Harnett County Government Complex
307 W. Cornelius Harnett Boulevard
Lillington, NC 27546

Re: The Perk on Broad
311 E. Broad St.
Dunn, NC 28334

The application for your proposed food service establishment has been reviewed but not approved. Below is a list of the reasons for the denial:

FLOOR PLAN - OPTION A 1  
 1/4" = 1'-0"

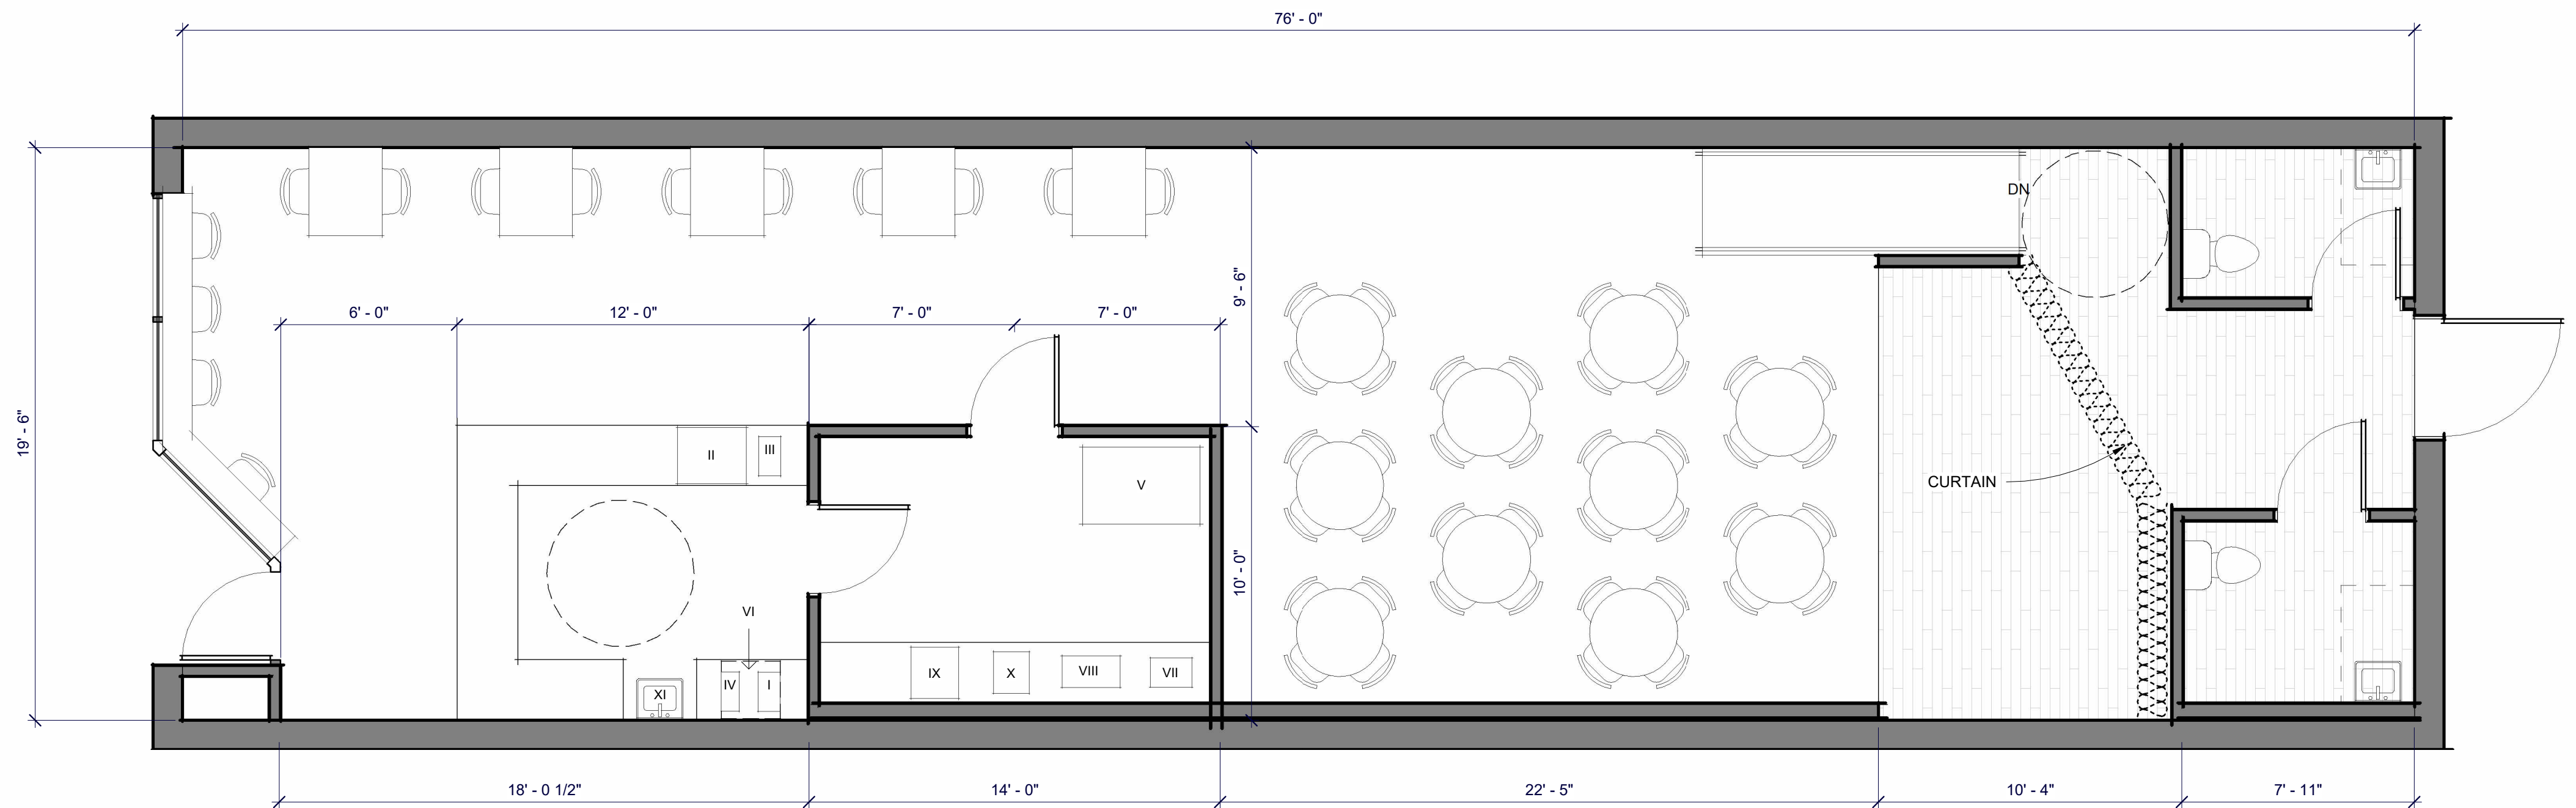
1. The application is not complete.
2. The food process sheets are not completed for the soups or deli meats.
3. The equipment specifications sheets were not provided for the equipment. All proposed equipment must be indicated on site plan including counter-top equipment.
